**Application no:** 18/00168/DISC

**Proposal:** Discharge of Conditions 6 (Parking Strategy Phase 1) 9 (timber bridge swale park west) 10 (LAPs and LEAPs) 11 (Landscape management for phase 1) of 16/01807/REM

**Location:** Site D And E Graven Hill Circular Road Ambrosden

## **Transport Development Control**

Drawing Title:
Proposed Bus Stop Details

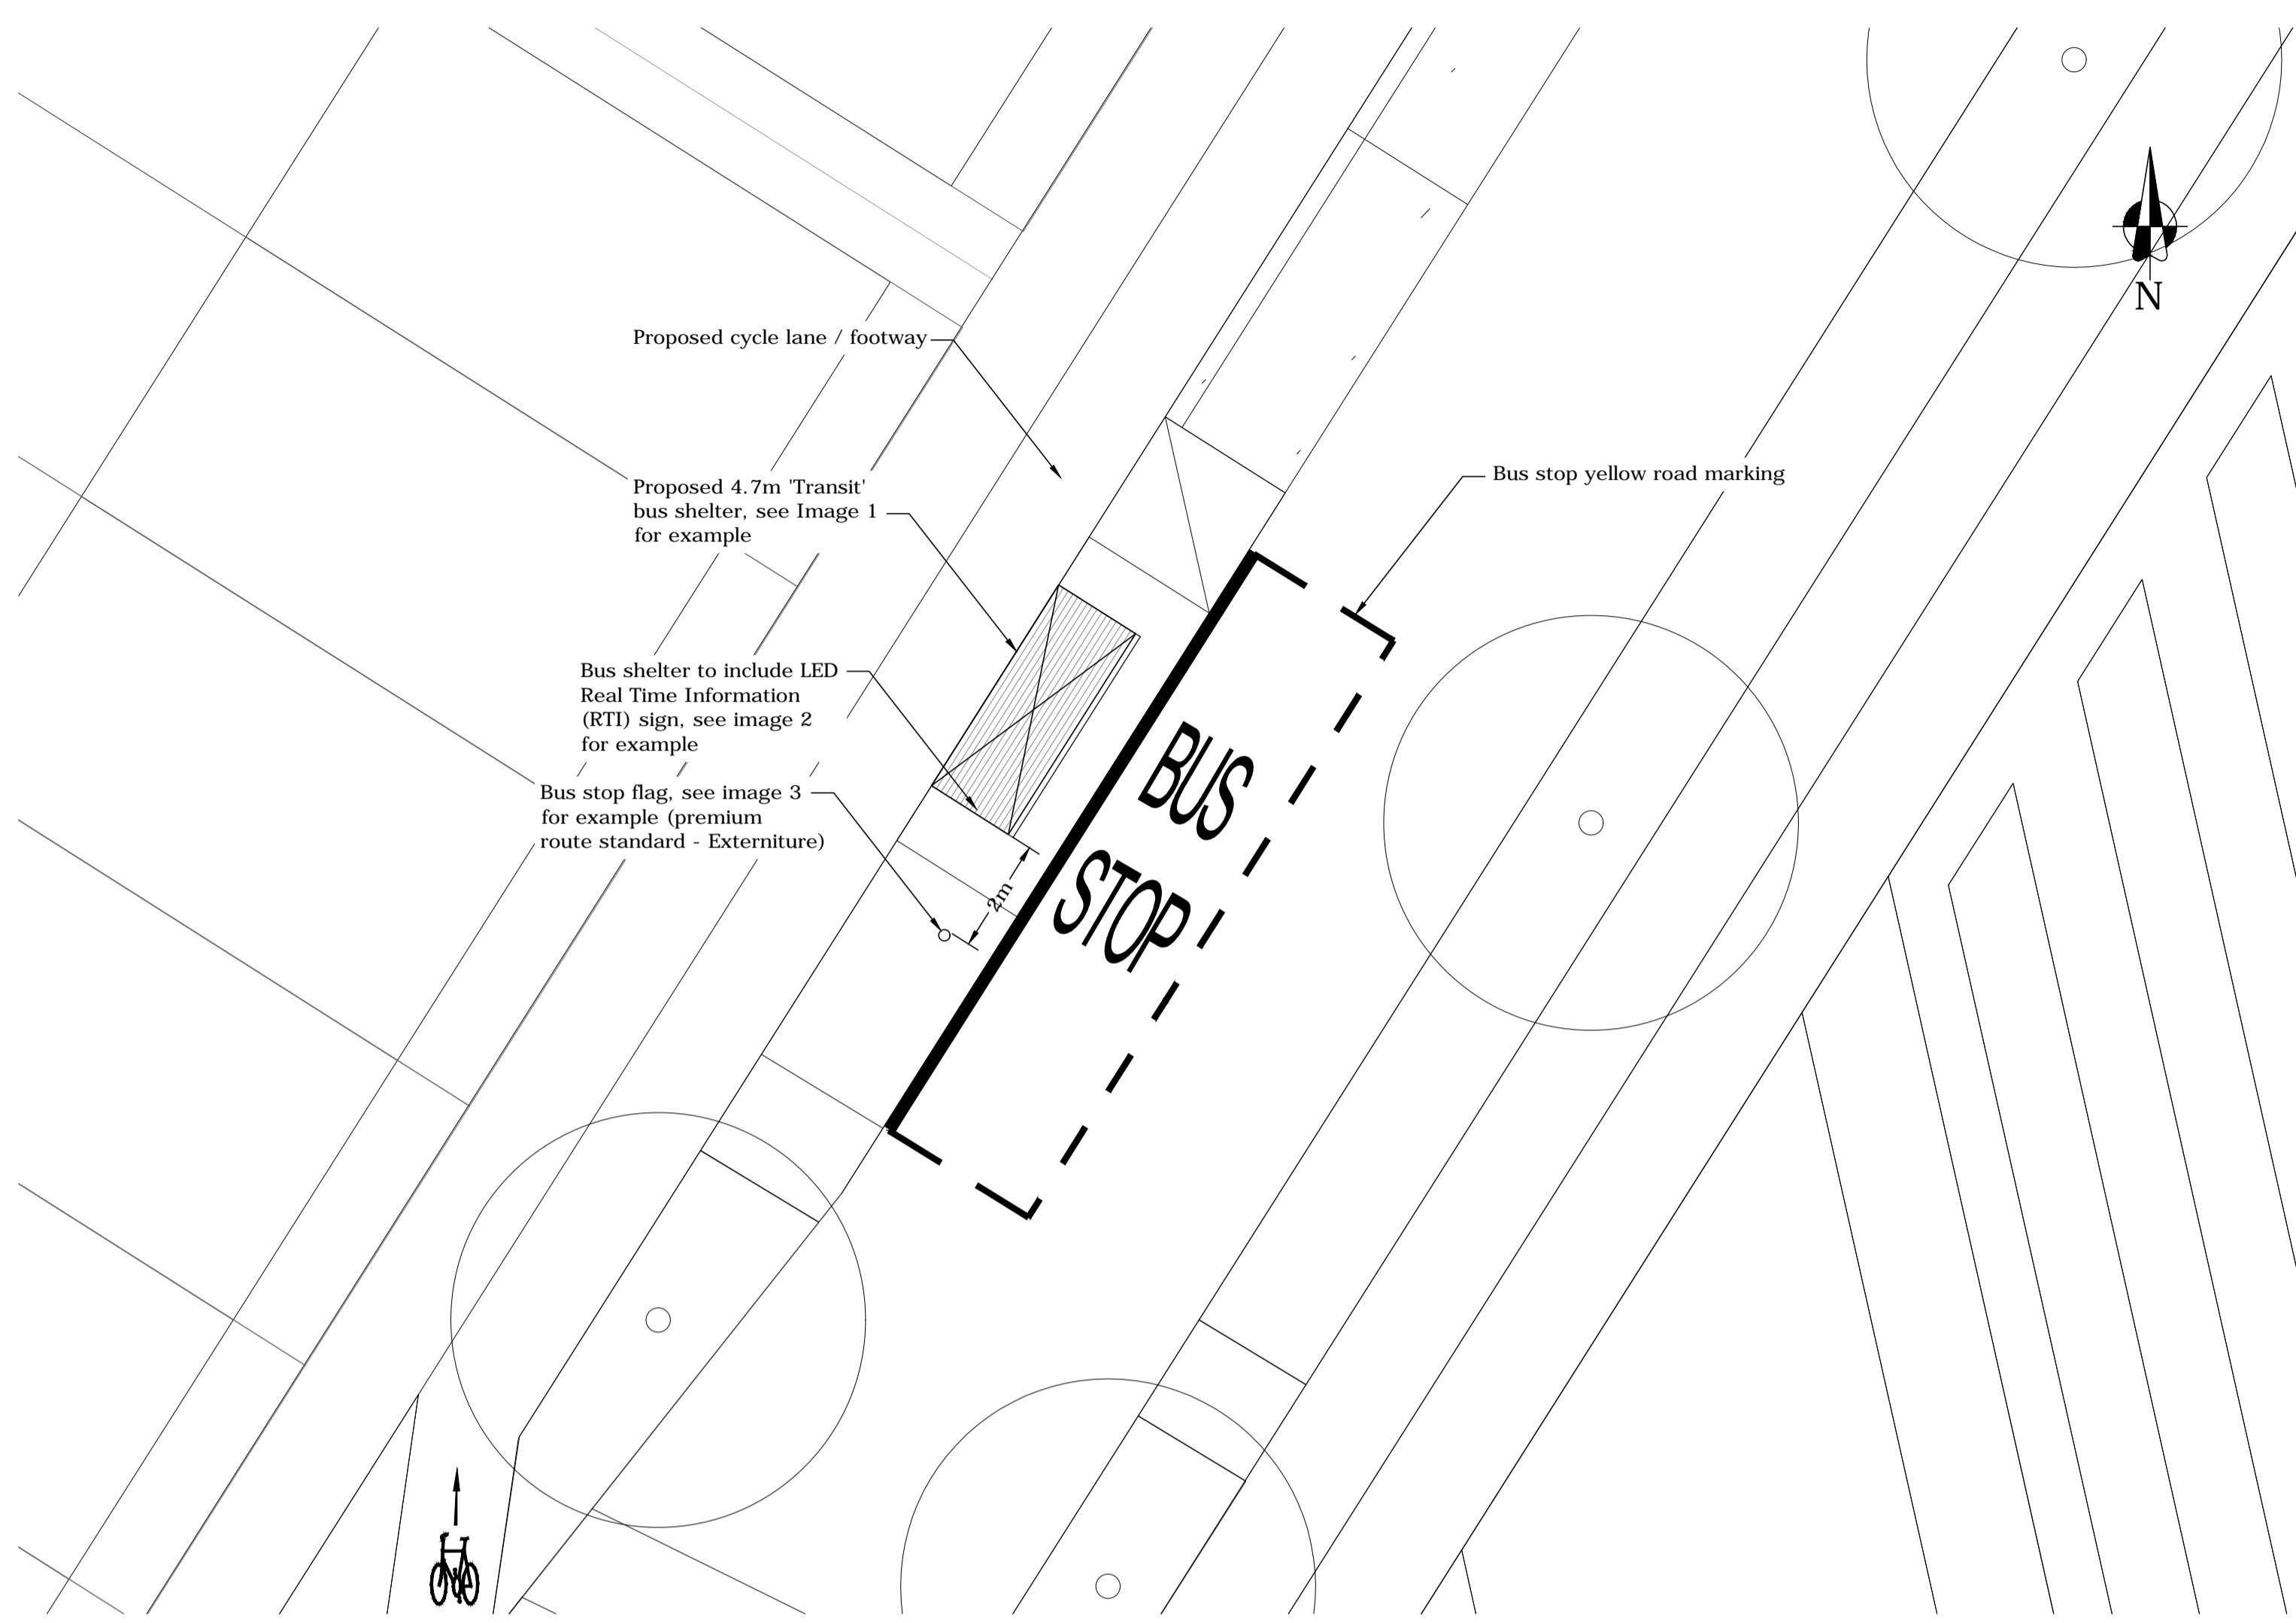
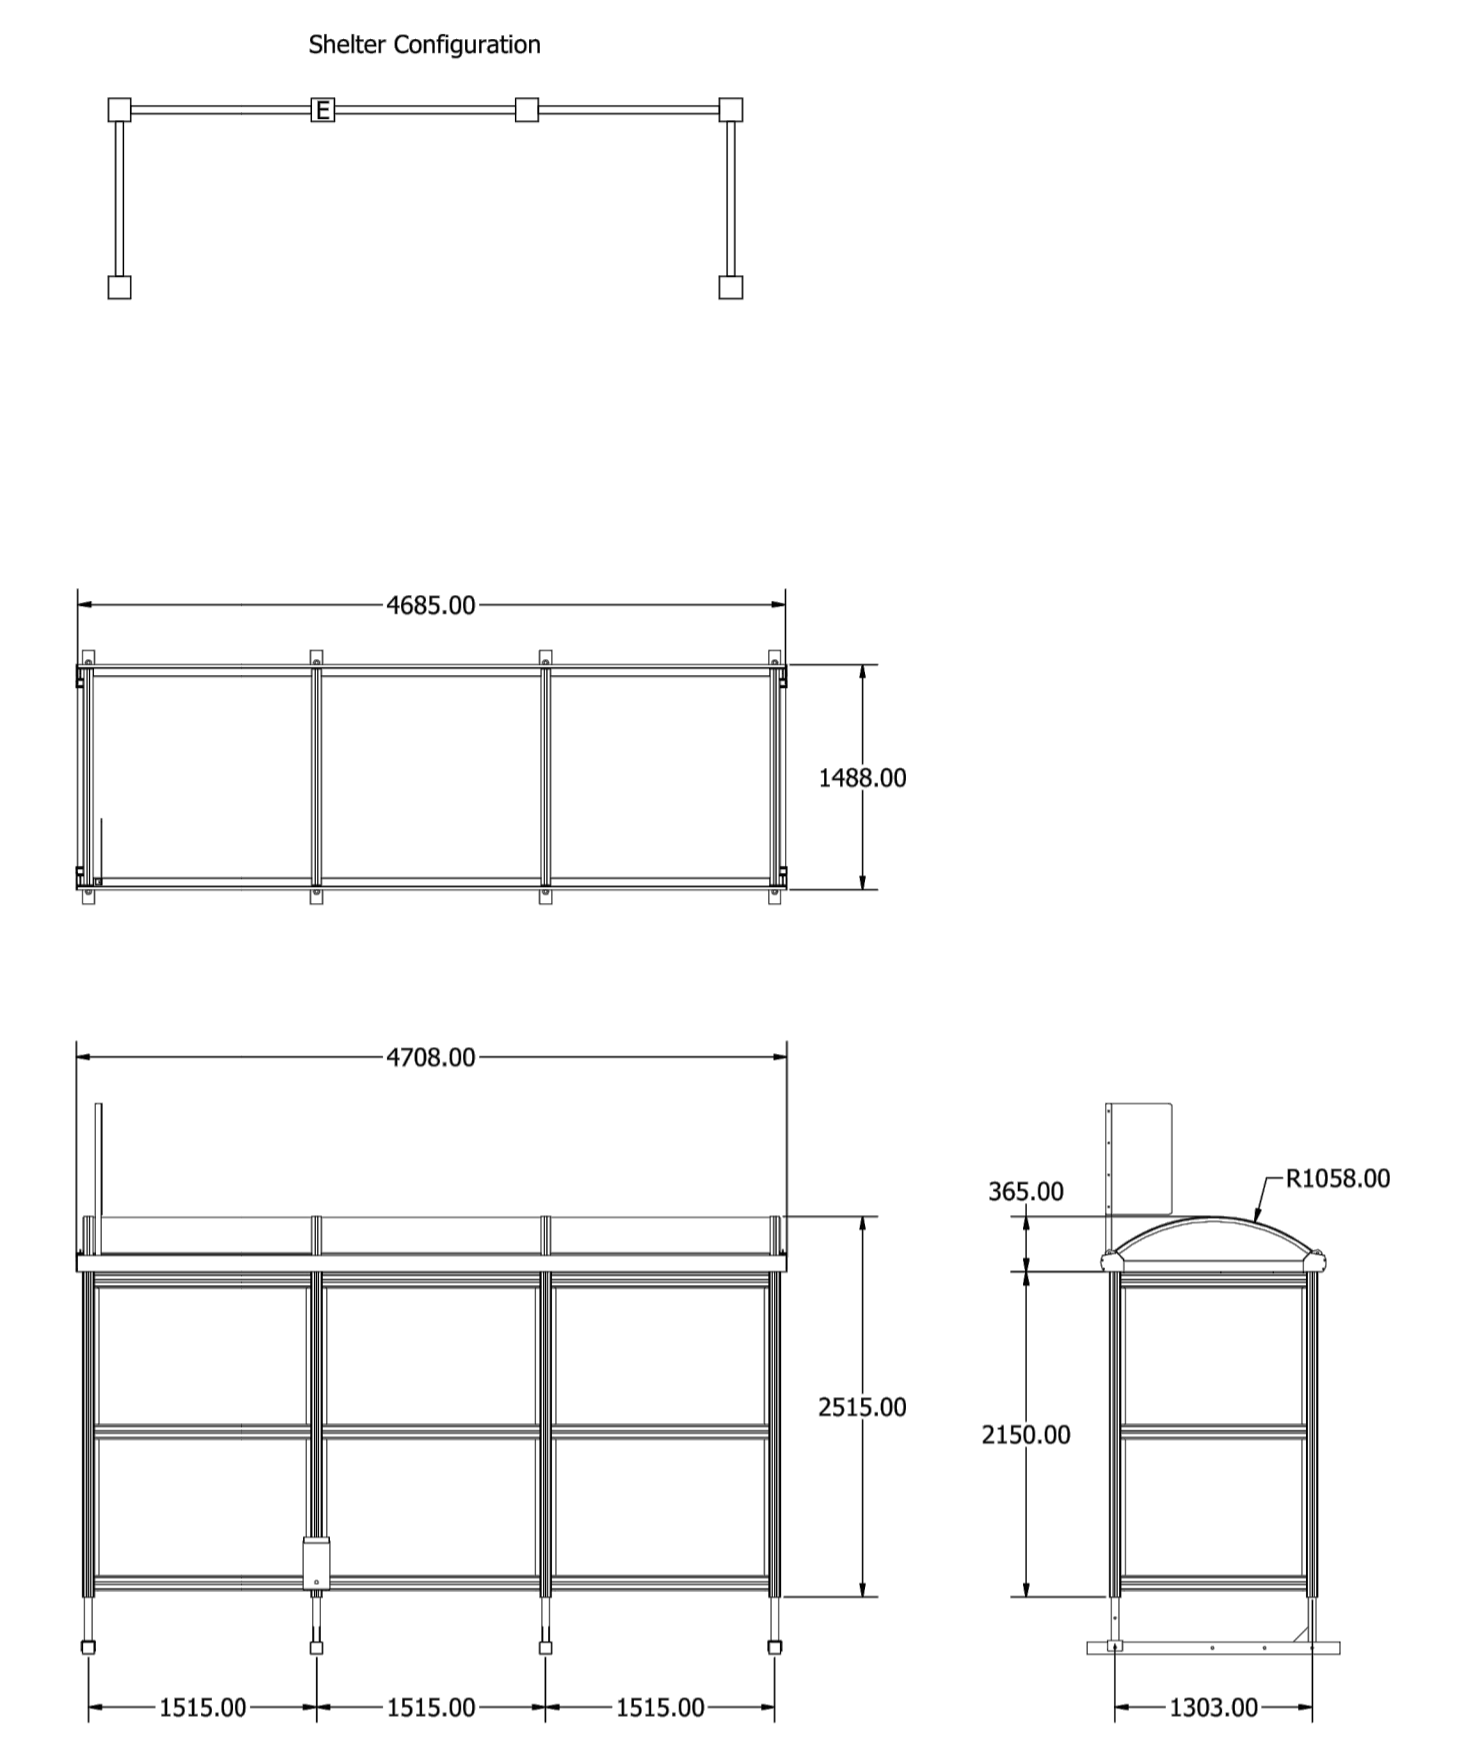
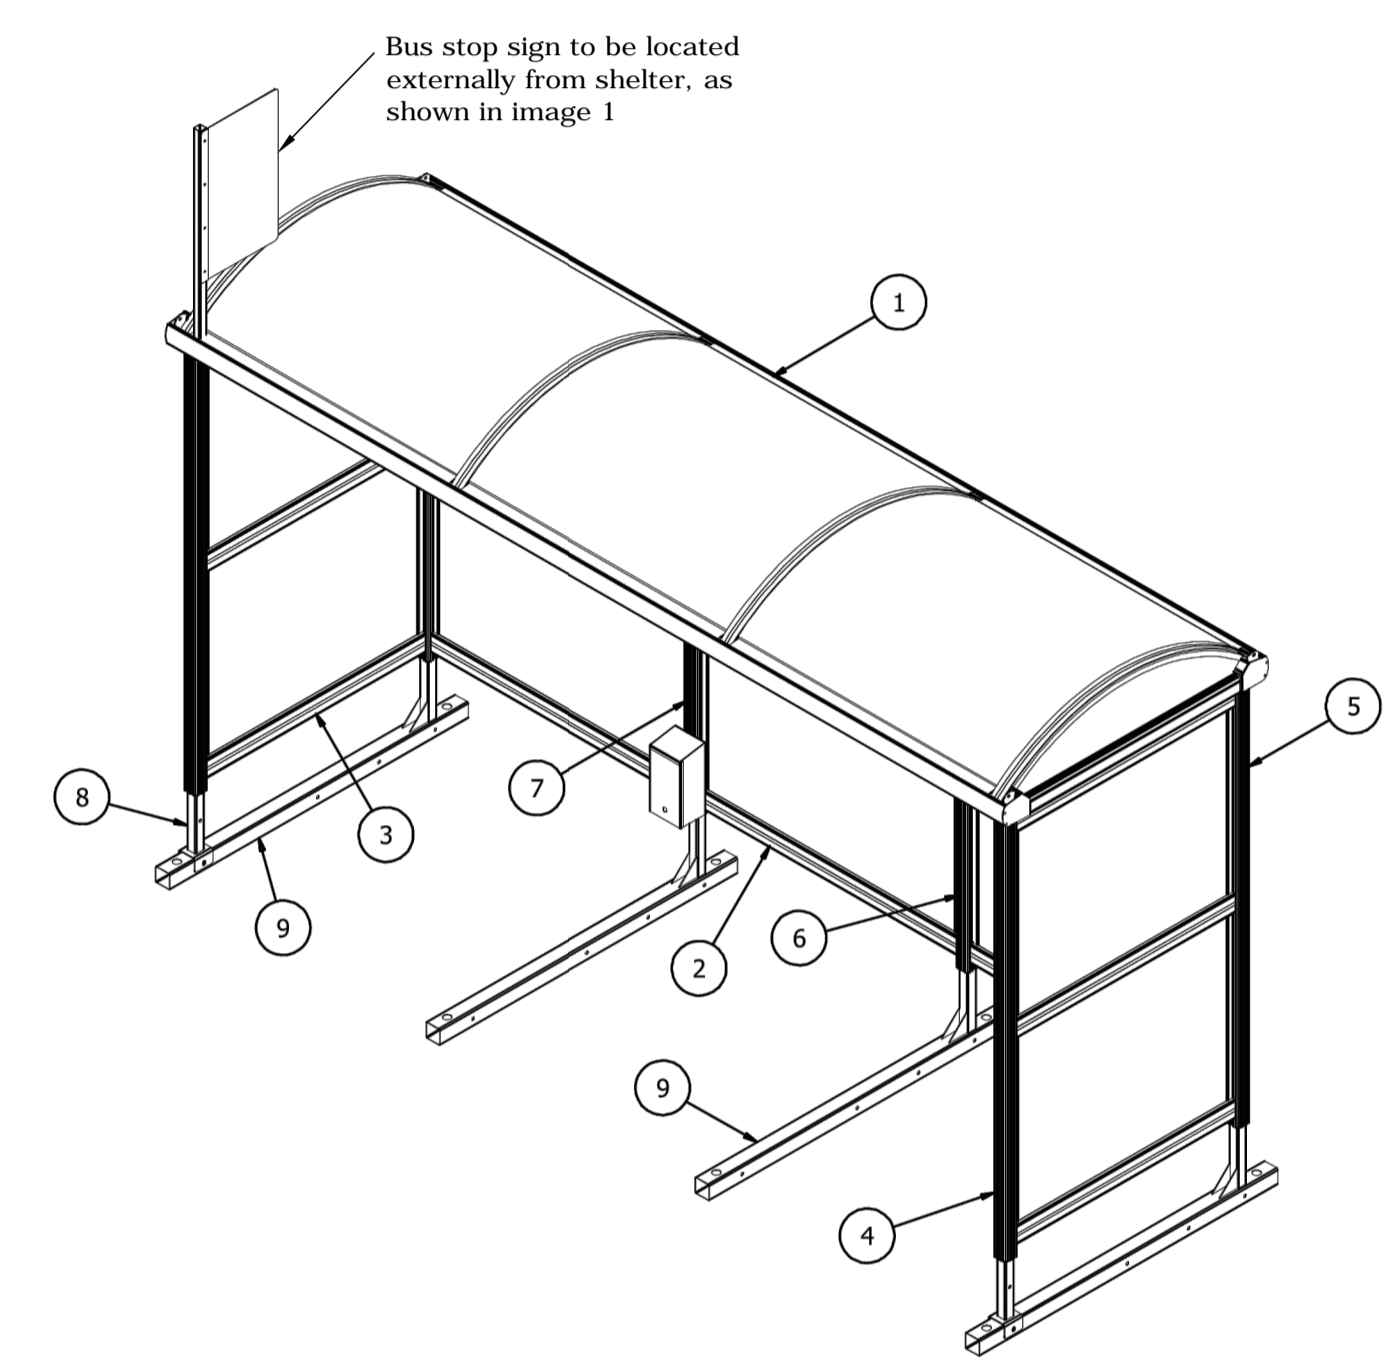
The bus stop details plan does not include any information about electrical connections. Amended plans will be required to show this detail, the plans submitted at present will therefore need to be superseded and replaced.

A 'haldo' feeder pillar will be required for each shelter, ideally located at the opposite end of the shelter to the display, and outside the shelter structure. The illuminated RTI sign should be located facing the oncoming bus as this is the direction that passengers will be facing. OCC technical details below and attached.
